CITY OF ALBUQUERQUE

August 8, 2018

**Re: McMahon Carwash
McMahon and Fineland
Traffic Circulation Layout
Engineer's Stamp 07-30-18 (A11-D016A)**

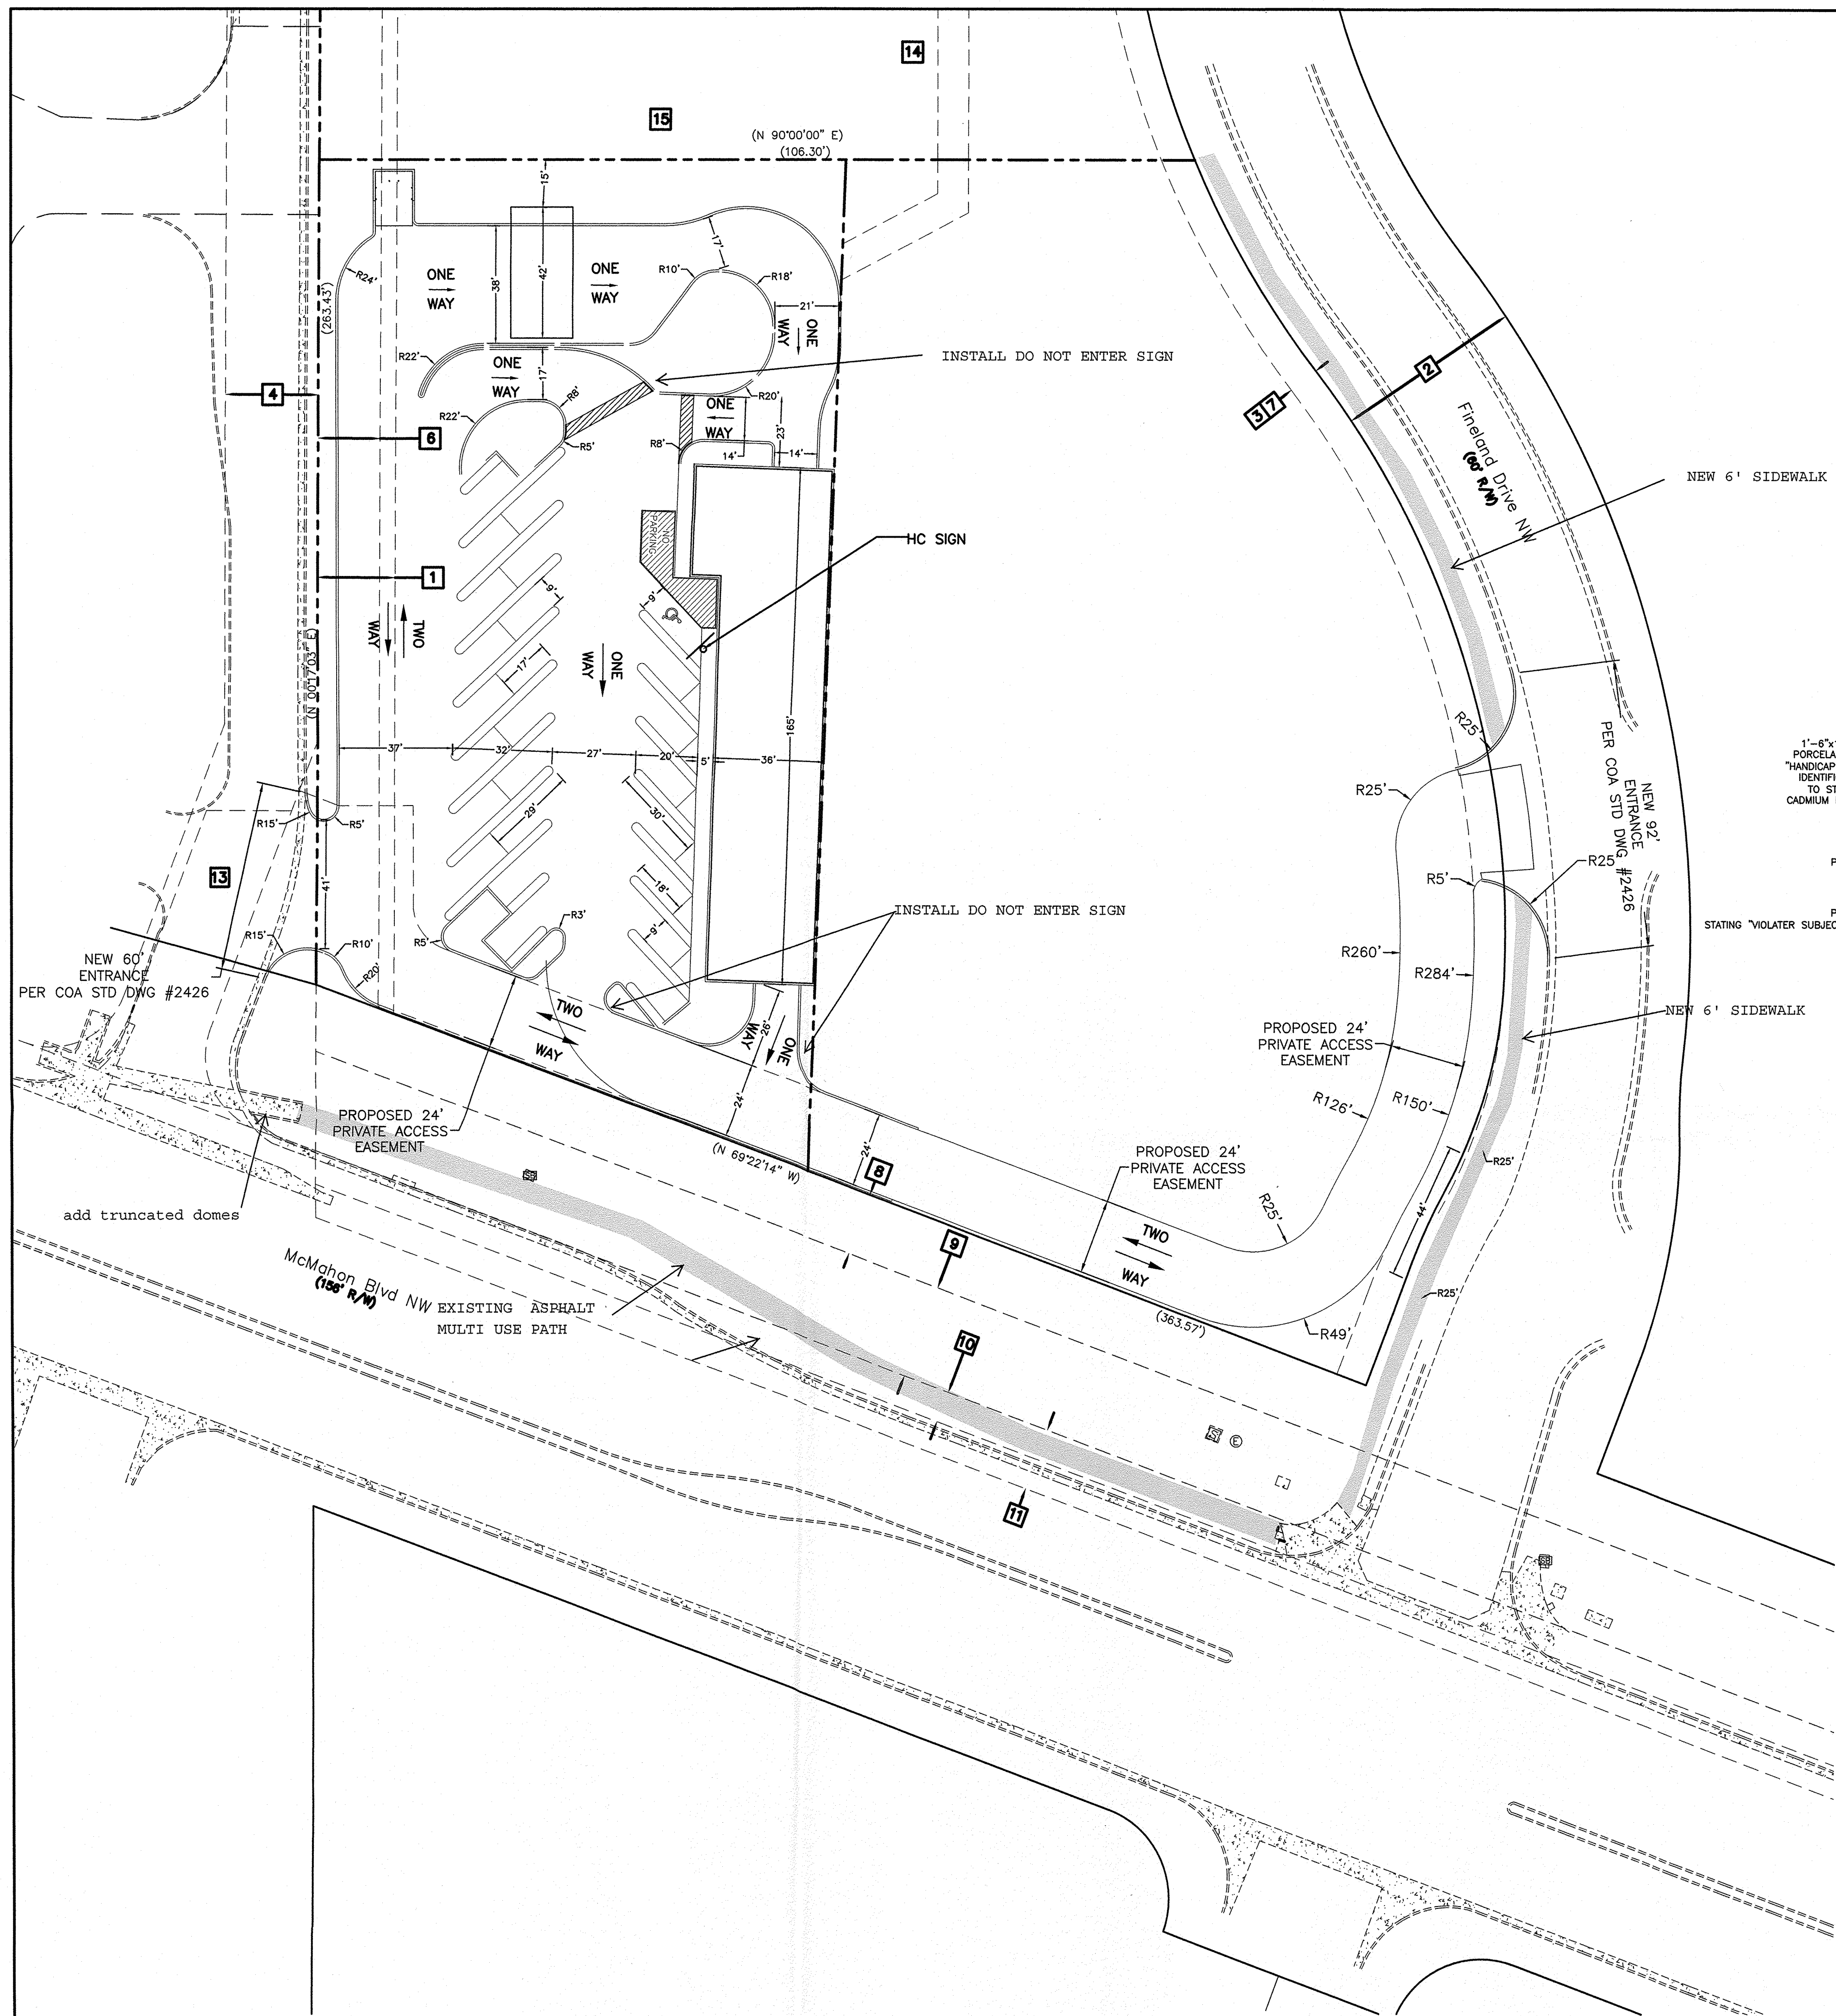
1. The drive way located Fineland needs to be shifted further away from the intersection.
2. Please dimension the entrance on the northwest side going into the carwash kiosk.

3. The ADA accessible parking sign must have the required language per 66-7-352.4C NMSA 1978 **"Violators Are Subject to a Fine and/or Towing."** Please call out detail and location of HC signs.

4. The ADA access aisles shall have the words **"NO PARKING"** in capital letters, each of which shall be at least one foot high and at least two inches wide, placed at the rear of the parking space so as to be close to where an adjacent vehicle's rear tire would be placed. (66-1-4.1.B NMSA 1978)

5. Please look at the one-way located at the top of the vacuum stalls this may need to be going the other direction. Also add **"Do Not Enter"** signs or stripes at the exit of each one-way. A directional arrow or one-way sign should be located at the end of the carwash bypass.

6. Truncated domes/ detectable warning surfaces should be added to the crosswalk located at the entrance on McMahon.
